**Bankfield Drive, Holmbridge
Proposed Internal Site Layout and Off-Site Works
Response Report to Road Safety Audit Stage 1**

November 2023 (Revision 3)

Report title	Bankfield Drive, Holmbridge Response Report to Road Safety Audit Stage 1 – Rev 3
Date	22 nd November 2023
Document reference and revision	Response Report to Road Safety Audit Stage 1- Rev 3
Prepared by	Optima Highways and Transportation Ltd
On behalf of	Kirklees Council

ROAD SAFETY AUDIT

JOB No	DRG No	REV
21043	101	F

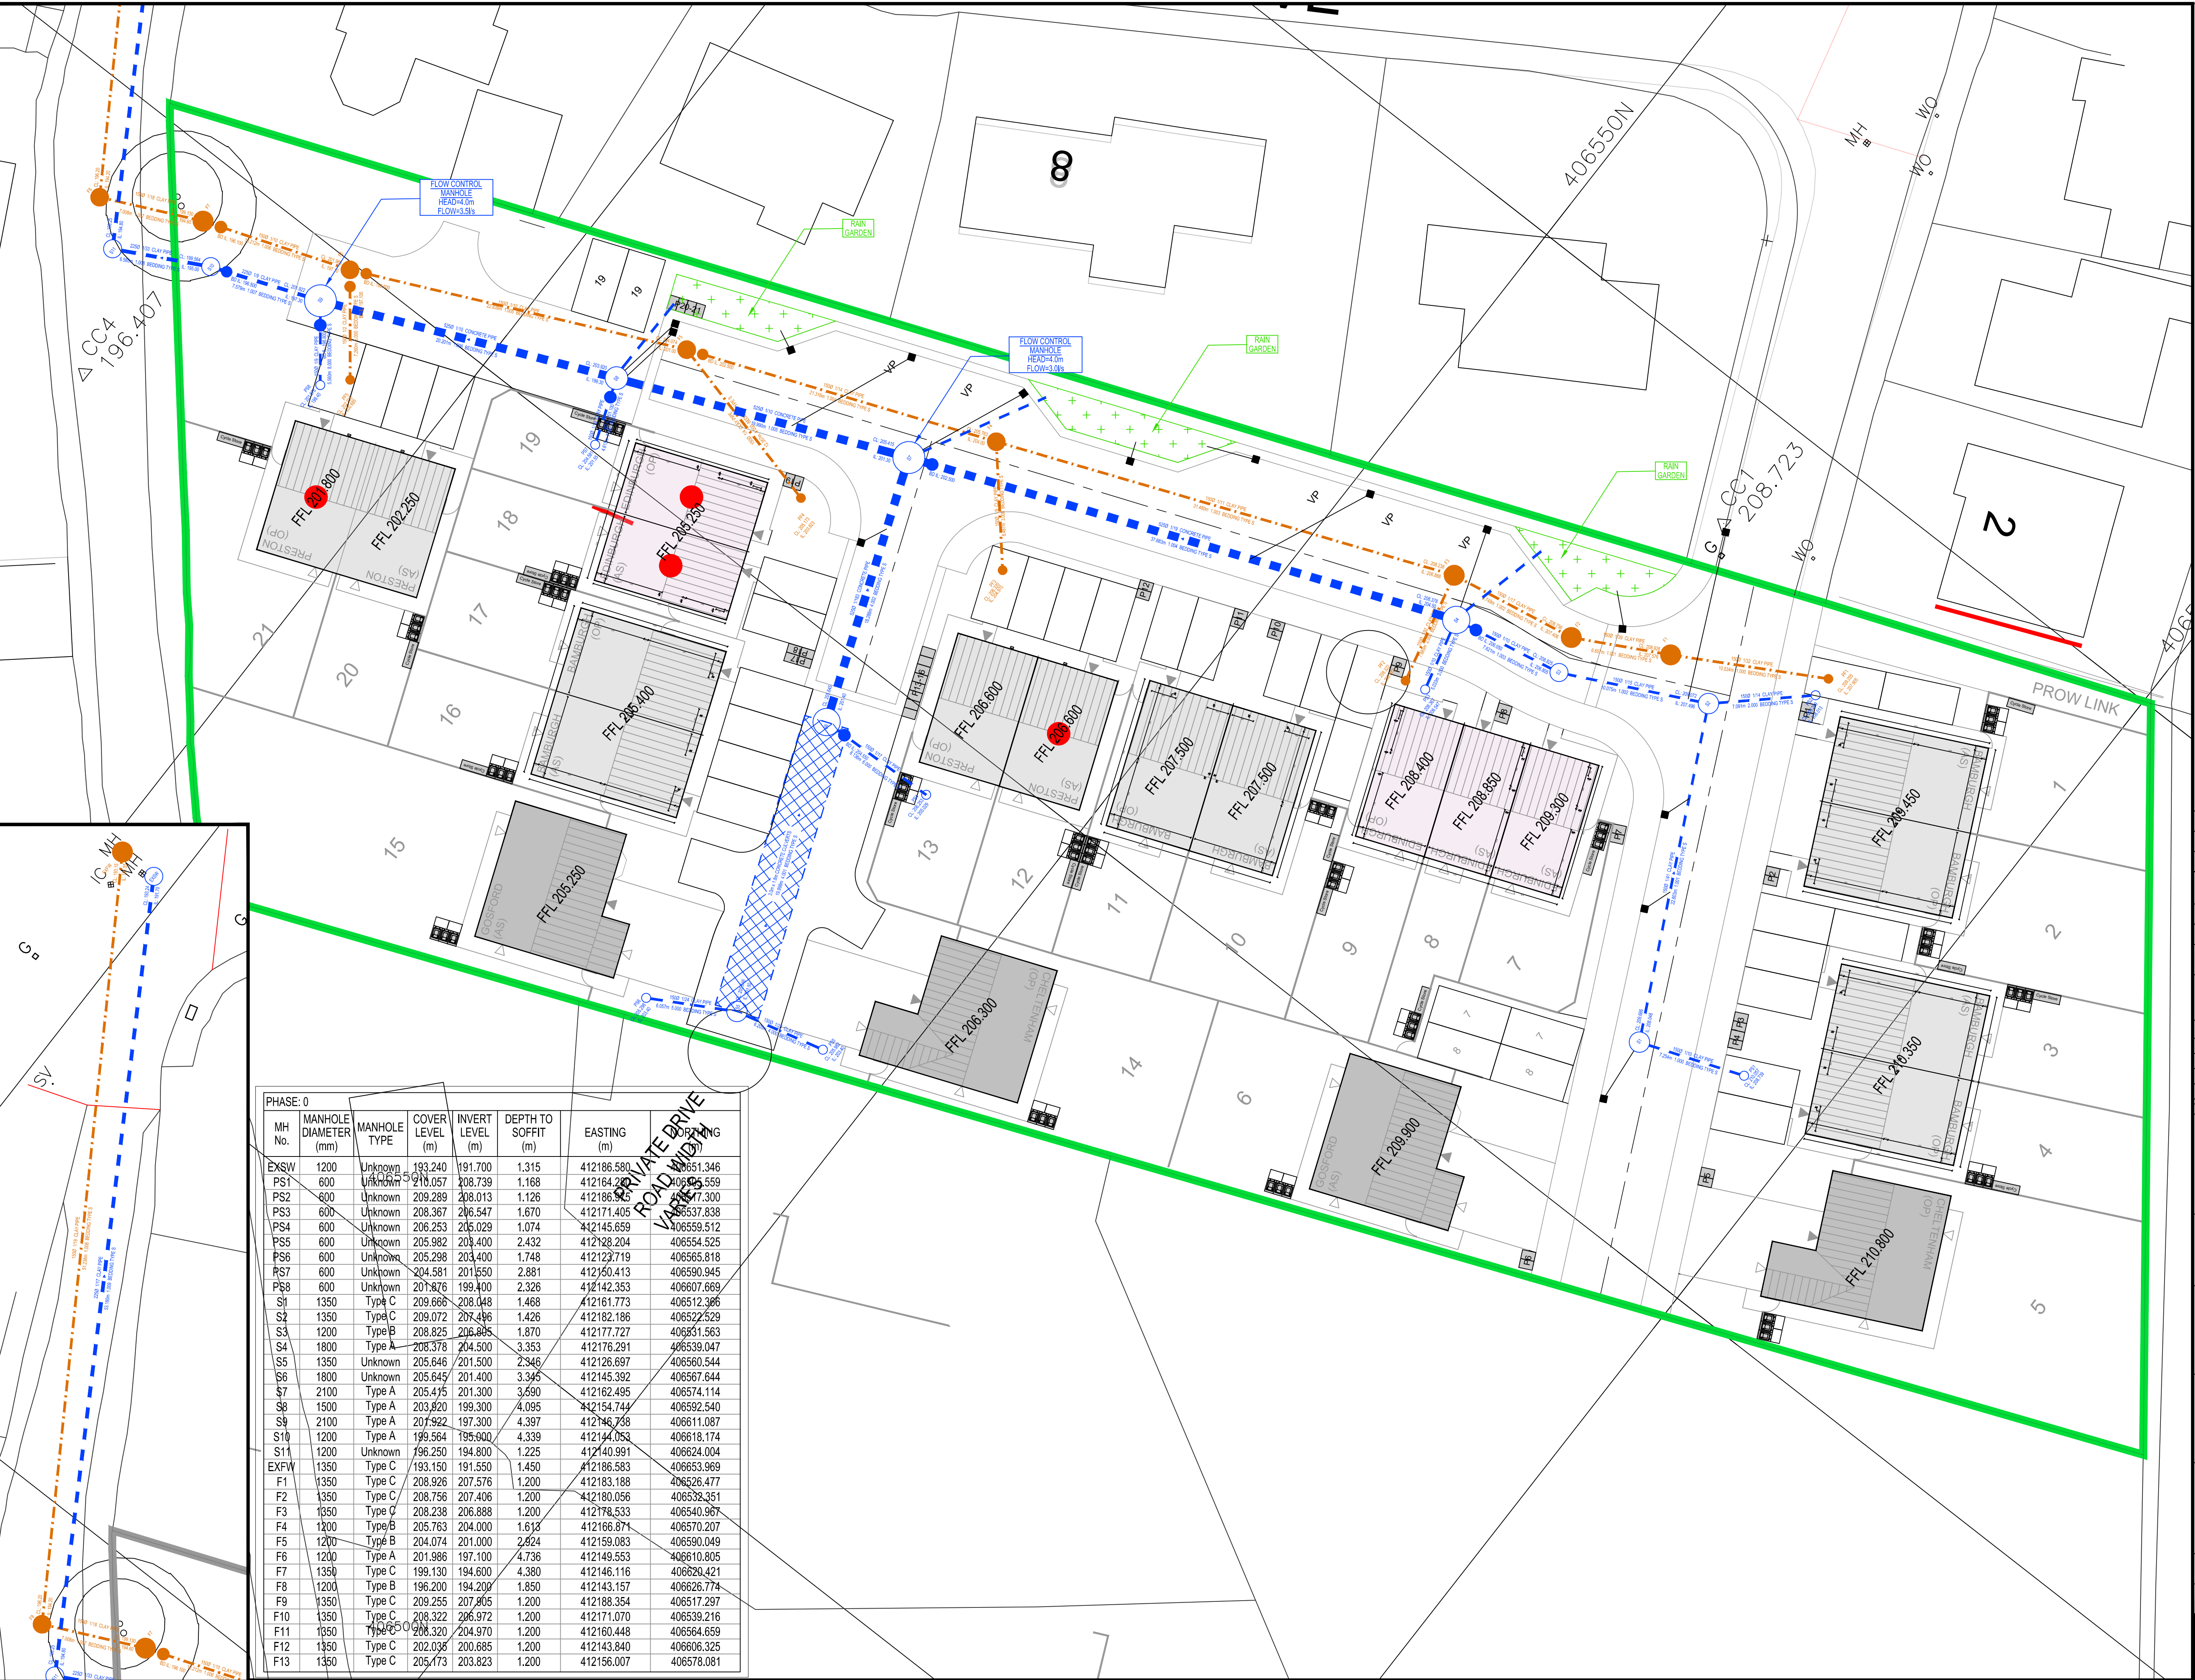
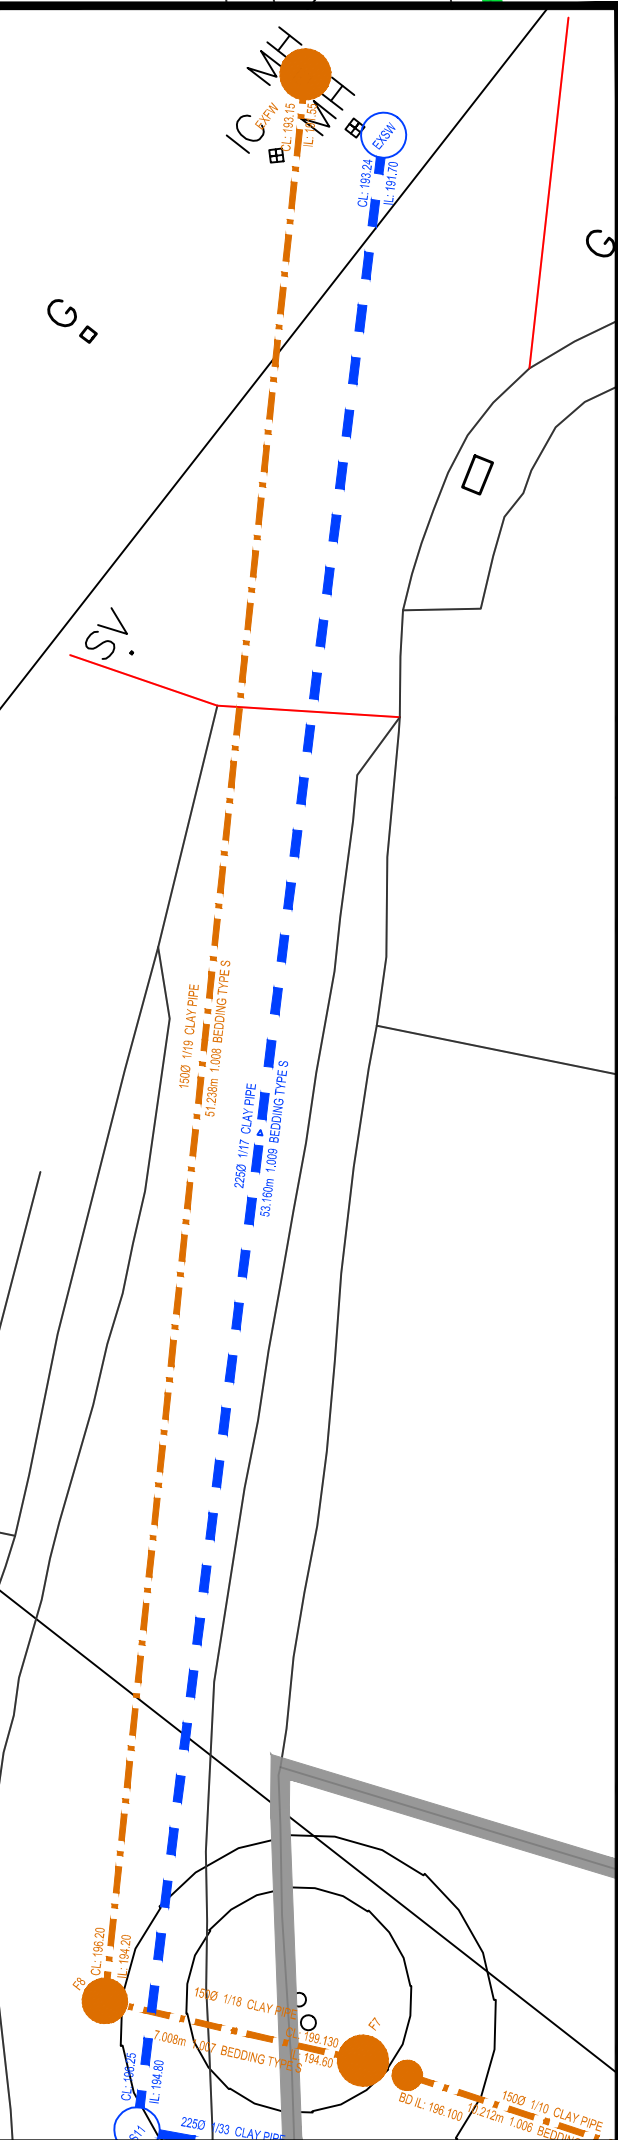
1.5.1 Problem: Gully provision

Summary: *The drawings provided do not show the provision of double gullies at low spots which could lead to flooding and loss of control incidents in cold weather.*

On examination of the drawings provided, the Audit Team have noted that there are no double gullies proposed at low spots – whilst this is not mandatory it is considered good practice to provide these to overcome any concerns over gullies being blocked.

It is recommended that the drawings be amended to provide double gullies at all low spots.

RSA Problem	RSA Recommendation	Design Organisation Response	Overseeing Organisation Response	Agreed RSA Action
1.5.1 Problem: Gully provision Location – New access road serving development Summary – The drawings provided do not show the provision of double gullies at low spots which could lead to flooding and loss of control incidents in cold weather. Detail – On examination of the drawings provided, the Audit Team have noted that there are no double gullies proposed at low spots – whilst this is not mandatory it is considered good practice to provide these to overcome any concerns over gullies being blocked. Failure to provide adequate and maintenance free drainage of carriageways could lead to ponding and flooding and potential loss of control incidents in cold and icy weather.	It is recommended that the drawings be amended to provide double gullies at all low spots.	Advant Engineers amended drawing S104 Drainage Layout Plan – 21043/101/Rev F. Drawing now shows double gullies at low points – see updated drawing attached at Appendix B.	The RSA Recommendation and Design Organisation Response is accepted in principle. However, the final drainage details, including gully types and locations etc. will need to be agreed at the S38 Technical Approval stage.	Double gullies have been shown on the Advant Engineers amended drawing S104 Drainage Layout Plan – 21043/101/Rev F. The final drainage details, including gully types and locations etc. will be agreed at the S38 Technical Approval stage.
